CITY OF ALBUQUERQUE

RE: Tin Can Alley
6100 Alameda NE
Grading & Drainage Plan and Drainage Report
Engineer's Stamp Date: 05/15/19
Hydrology File: C18D086

**RE: Tin Can Alley
6100 Alameda NE
Grading & Drainage Plan and Drainage Report
Engineer's Stamp Date: 04/22/19
Hydrology File: C18D086**

1 | grading and drainage plan
c101 1"=20'

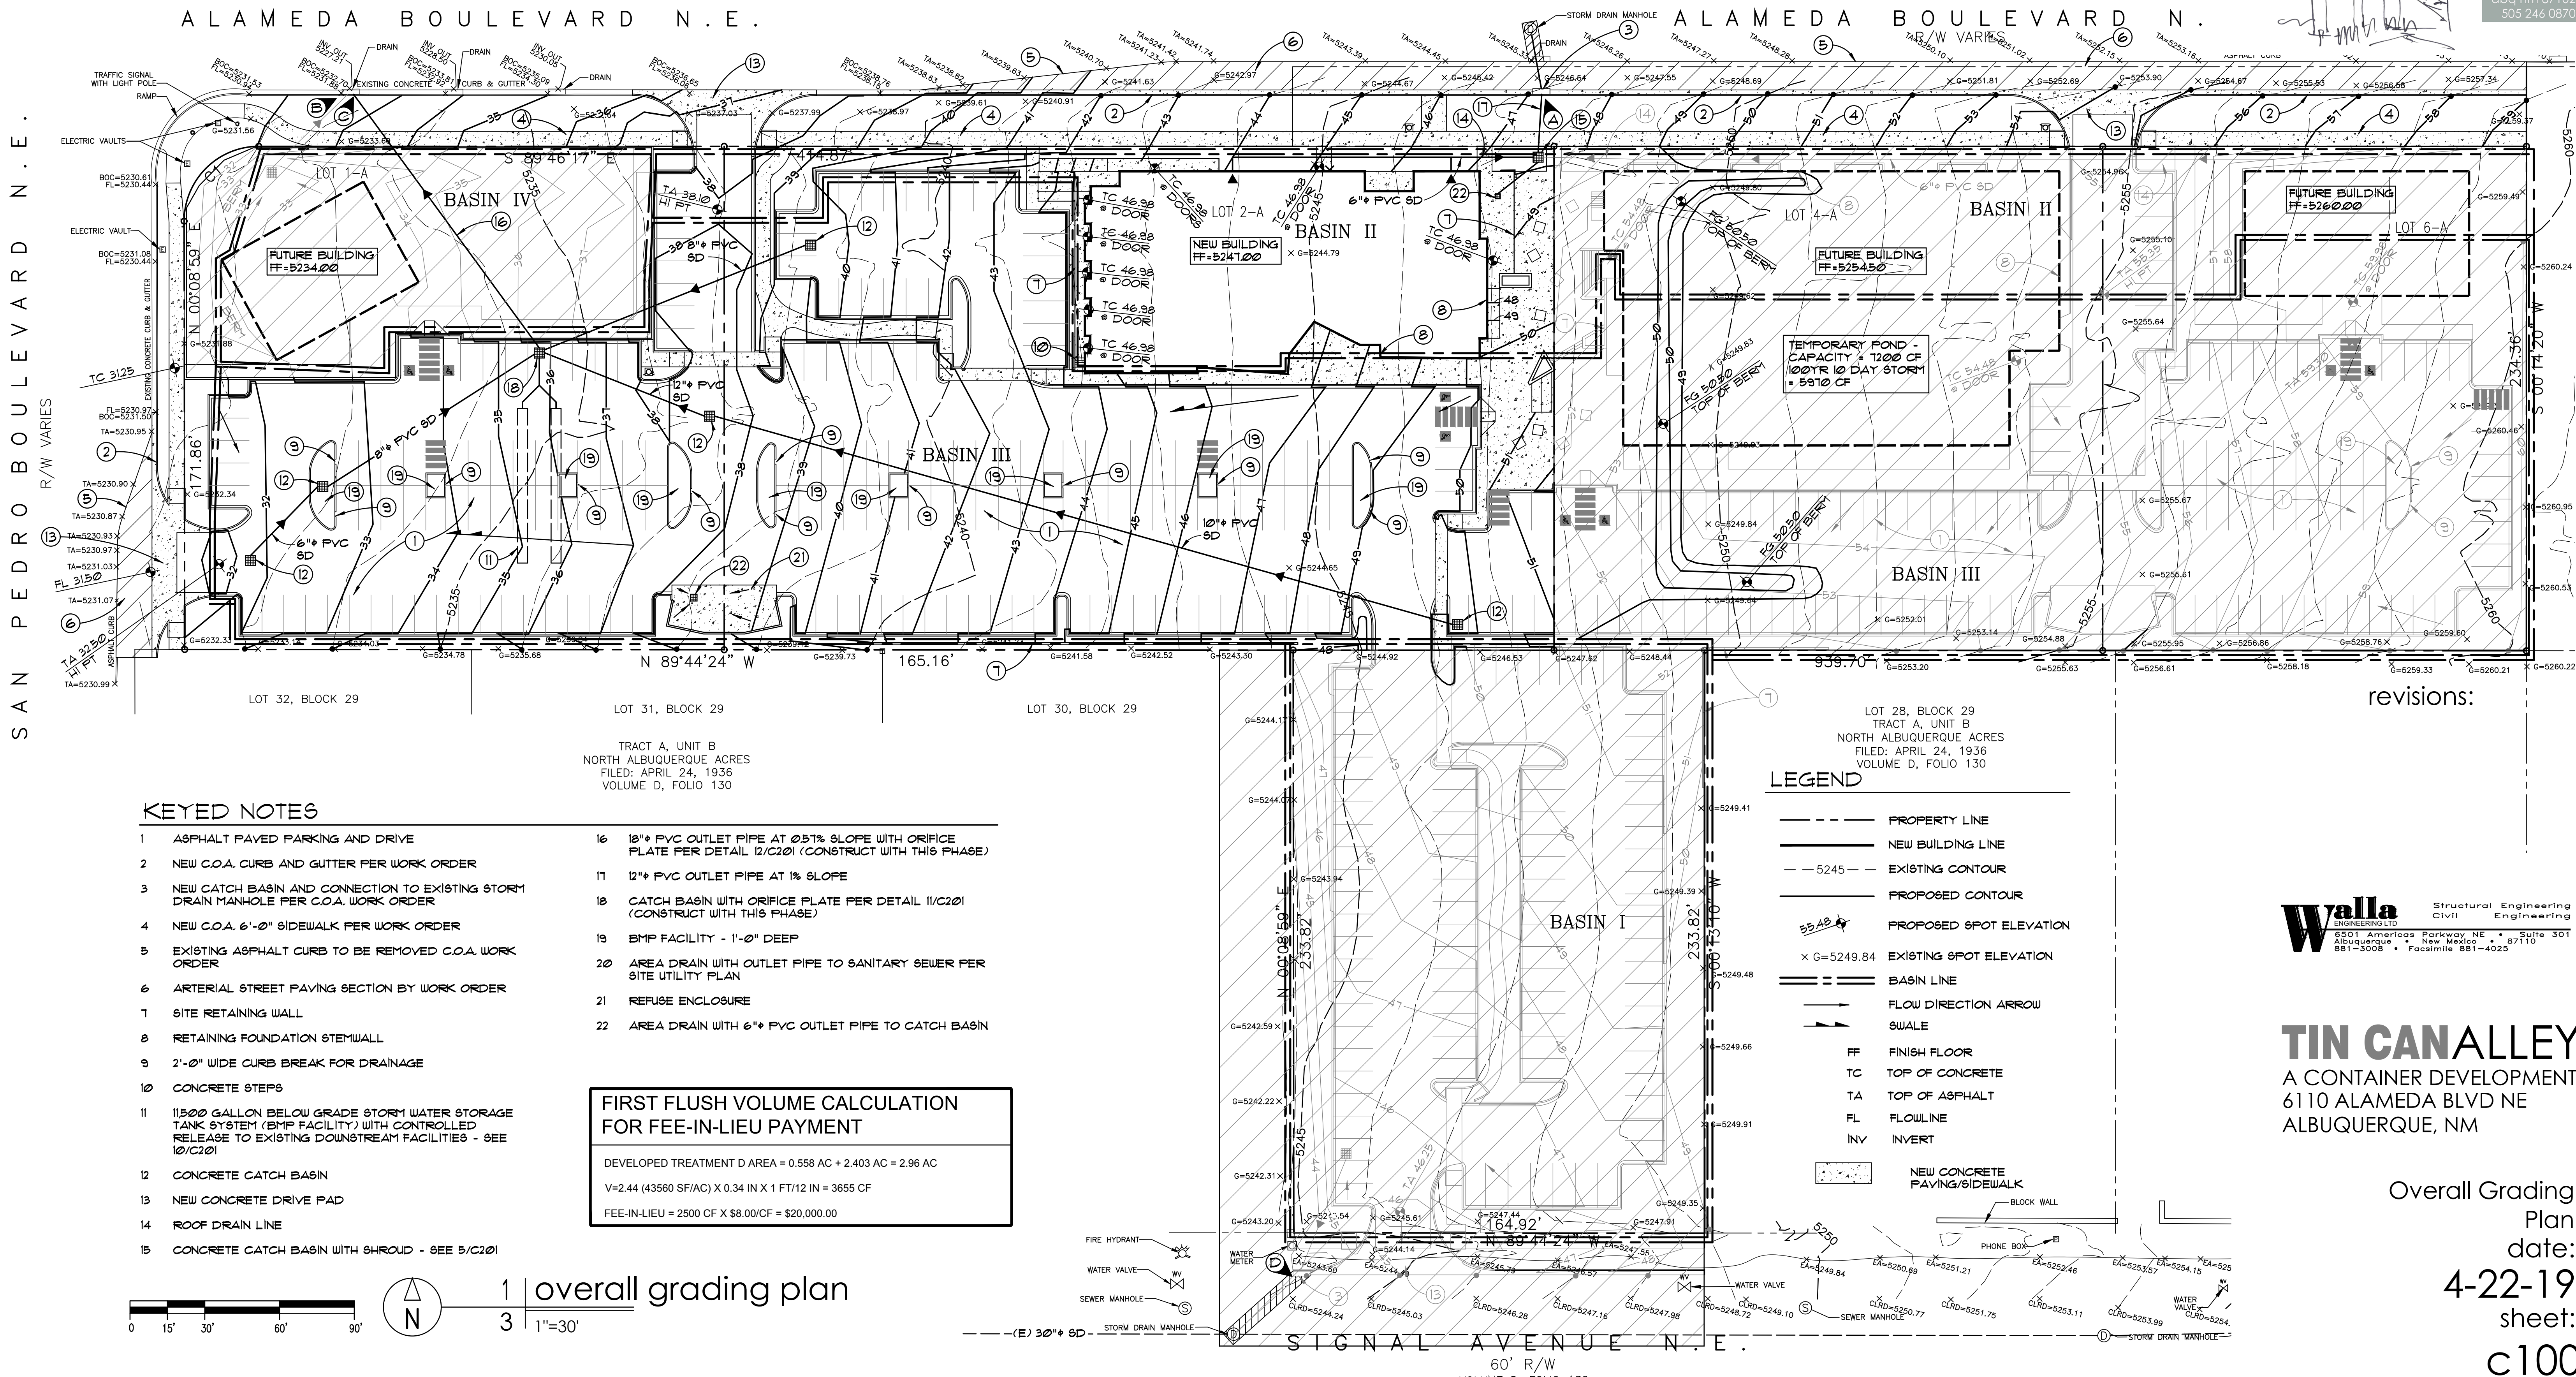
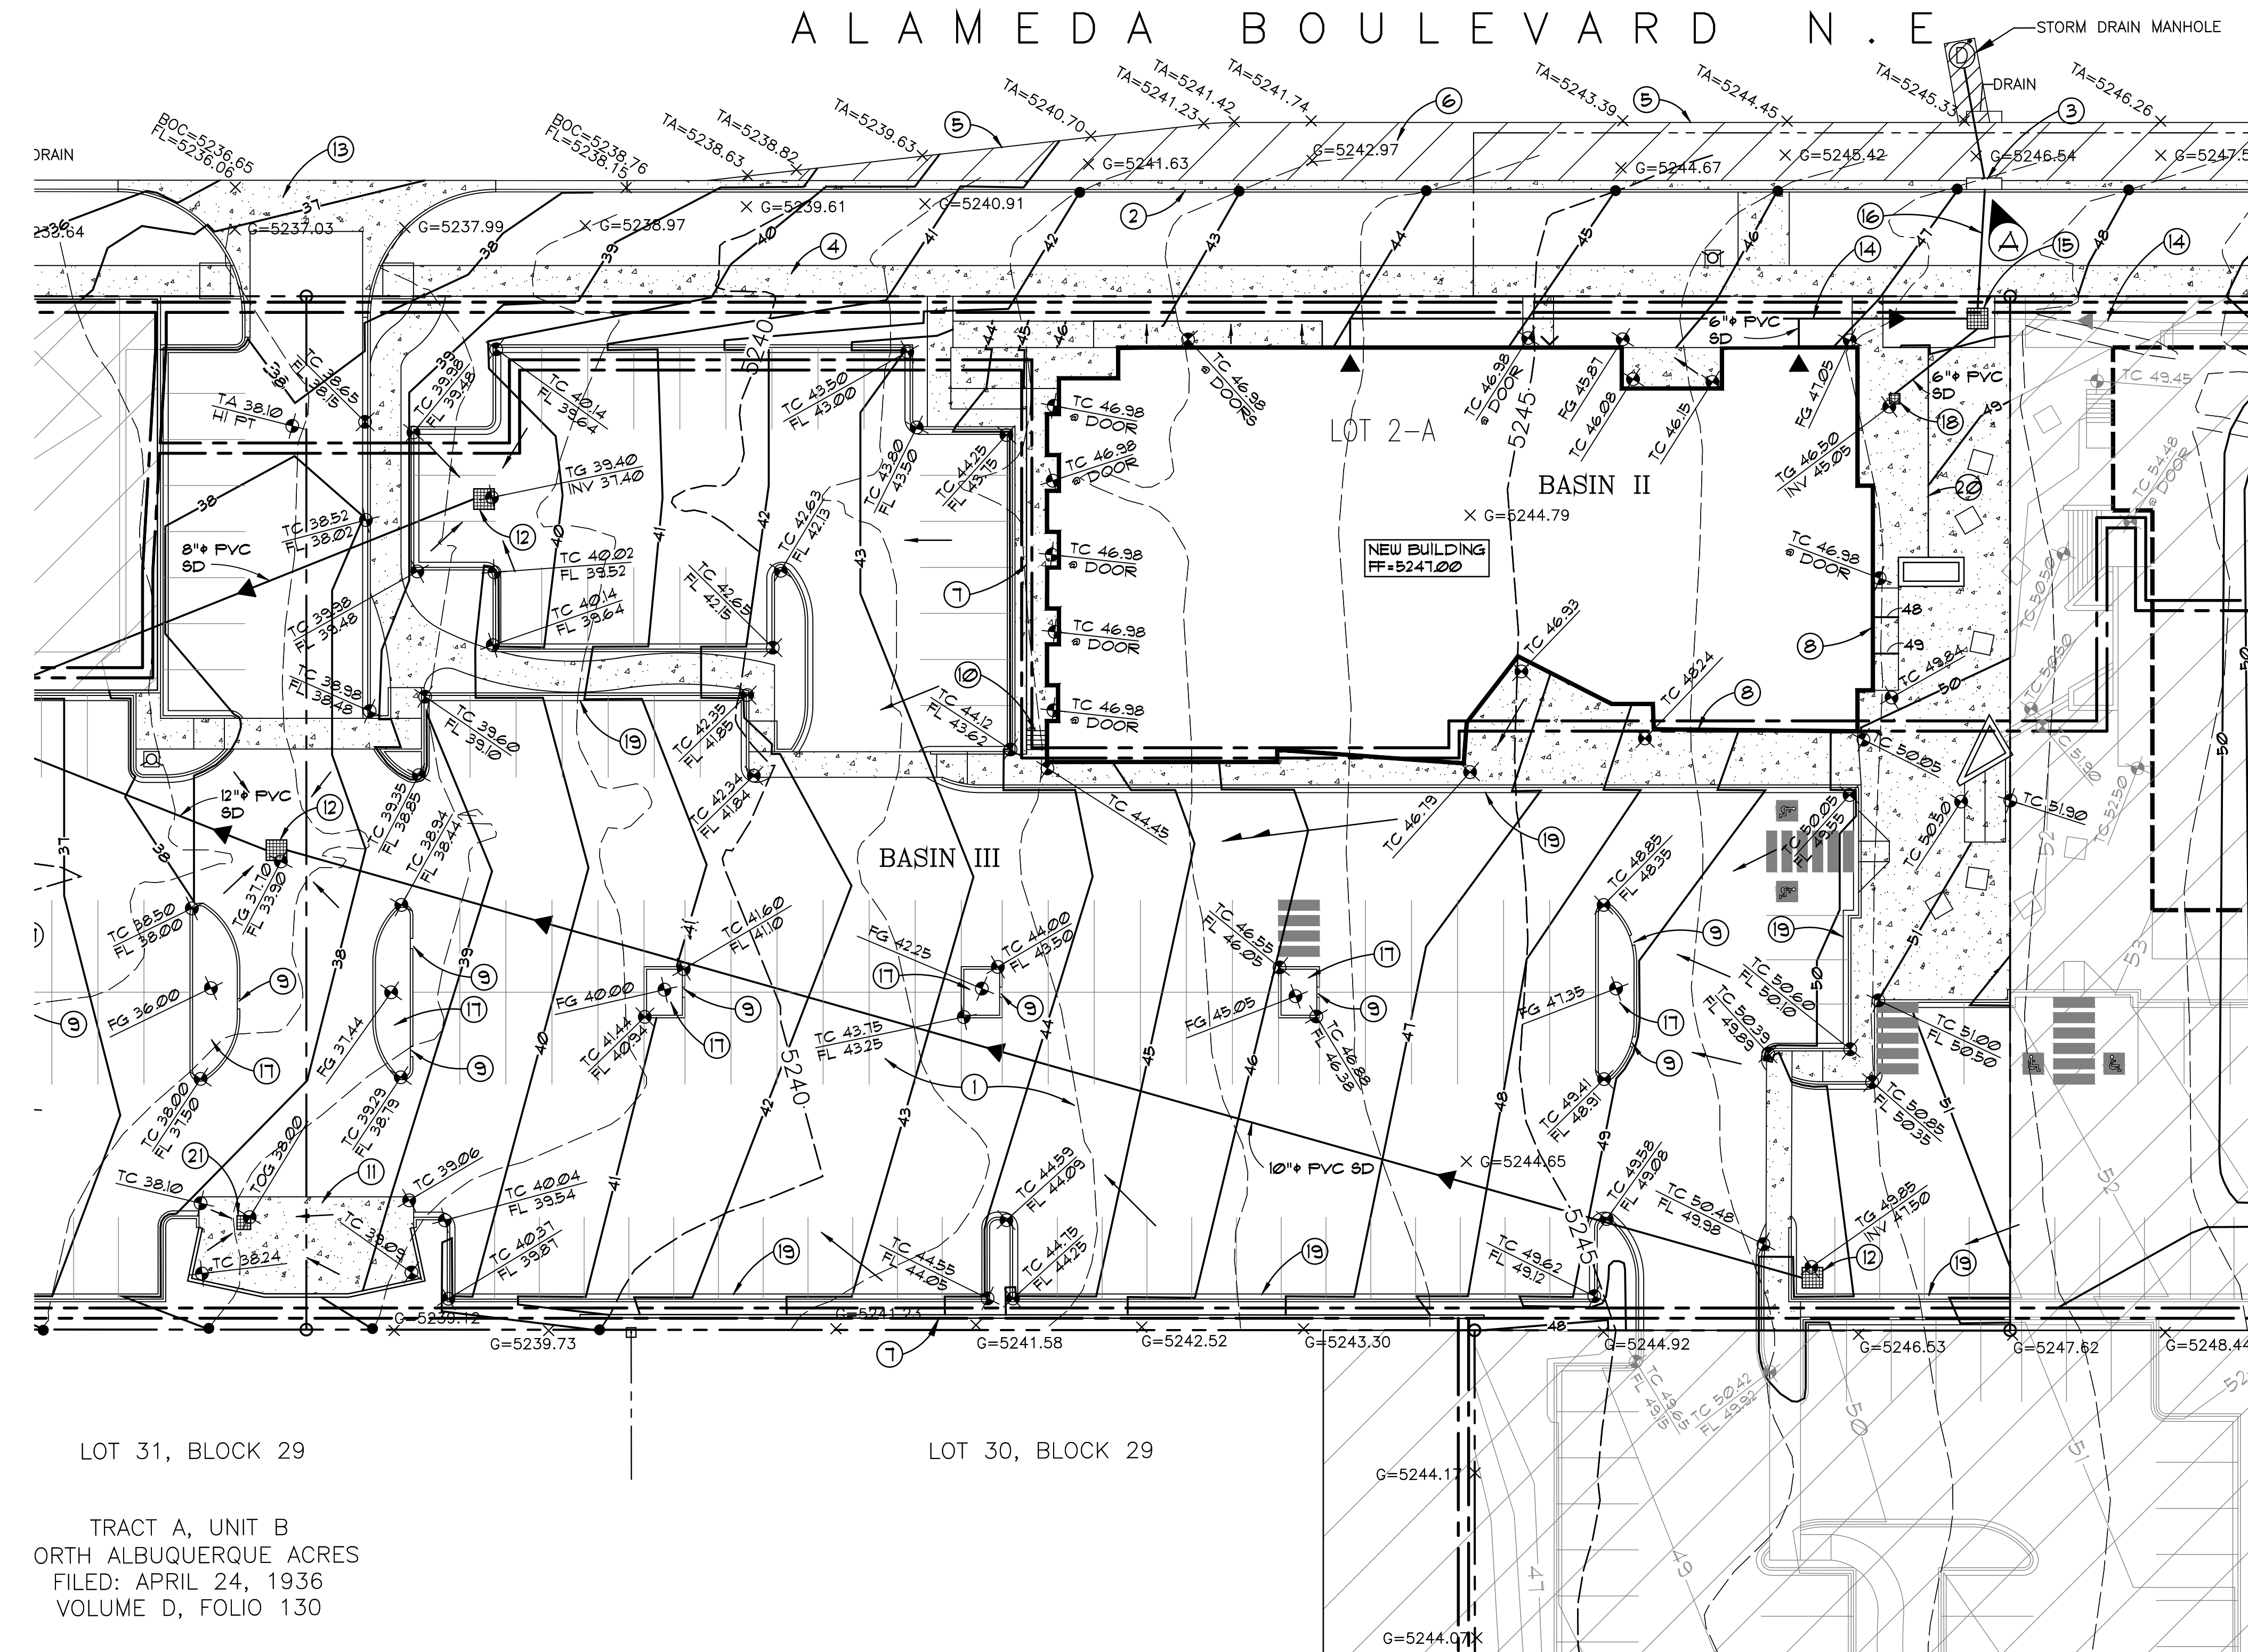
1. The HGL in the manhole in Alameda is 5231.1. Starting here and traveling through the proposed storm system, the HGL at the inlet (note 15) is 35.37 and rim of 35.75. This means that the proposed underground detention and all downstream storm sewer will not be able to discharge into the storm system and will easily go over the waterblock of 32.50 at San Pedro. Therefore, we propose two solutions.

- a. Do a complete study for the installation of inlet(s) on San Pedro along with the upsizing of the existing 48-inch pipe to probably a 60-inch and a manhole. This infrastructure will have to go back to the DRB for a revised Infrastructure List approval. This option seems to be costly and more time consuming so I suggest the second option.

- b. This option eliminates the underground detention facility and installs instead a retention pond along San Pedro for the ultimate development. The total allowable discharge to Alameda is $3.82 \text{ cfs/ac} \times 4.345 \text{ ac} = 16.59 \text{ cfs}$. Basin II is free discharge of 4.37 cfs and a remainder allowable discharge of 12.22 cfs. Basin III & IV have a 100 yr – 6 hr runoff of 15.9 cfs. 15.9 minus 12.2 leaves 3.7 cfs for retention. We will allow for the 100 yr – 6 hr volume to be used instead of the 10 day. So using the DPM, the area for retention is $3.7 \text{ cfs} / 4.49 \text{ cfs/ac} = 0.82 \text{ ac}$. The volume of retention is therefore $2.58'' \text{ (excess type D)} \times 0.82 \text{ ac} = 7,717 \text{ cf}$. Therefore a pond 20' x 80' x 5' (depth) will provide a volume of 8,000 cf. This

pond will be walled with a security fence around it so no one falls in. A waterblock will need to be created at the curb return just to the east of the proposed underground detention. (Location provided on plans) Basin III will stop at this waterblock and Basin IV will extend to the south. Not only does the underground detention facility be eliminated, but two additional inlets and pipes are eliminated as well. (Marked on the plans) The inlet just to the east of the new waterblock, needs to be lowered a bit. This maybe lowered to say TG 37.50. (Please check to ensure that this is enough so that the runoff does not just go over the new waterblock) From this inlet, the outflow pipe can then connect to the most easterly of the existing three inlets. This pipe should be able to discharge the allowable 12.22 cfs. The only other new pipe is from the inlet by the San Pedro entrance and goes to the retention pond. This option also has the benefit of lowering the elected Payment-in-Lieu amount. Please verify the correct amount. By my calculation, for 0.82 ac @ 90% impervious will need a stormwater quality volume of 910 cf. Since this will be handled within the required retention pond volume it can be subtracted from the site's deficit volume amount. The total site stormwater quality volume is 3655 cf – 1155 cf (provided) – 910 cf (retention pond) = 1,590 cf. The Payment-in-Lieu amount is 1590 cf * \$8/cf = \$12,720. This is a savings of \$7,280. Along with the savings of the revised storm sewer system, this is a better option than the first one.

2. Please reflect the Grading and Drainage Plans for whichever option that you chose.
3. Please reflect the Drainage Report for whichever option that you chose.
4. Please add the calculations for the temporary retention pond to the Drainage Report.

1. Following your recommendations we have eliminated the underground storage facility for storm water runoff and have designed a Retention Pond that will hold runoff from the western end of the Alameda Mixed Use project. The drainage basins have been revised to account for this change as have the runoff calculations for the affected basins.
2. Grading and Drainage Plans for project have been modified to reflect the recommended changes.
3. The Drainage Report has been revised to reflect the design changes recommended.
4. Temporary pond volume calculations have been added to the Drainage Report and slight modifications to this pond are reflected on the drawing.
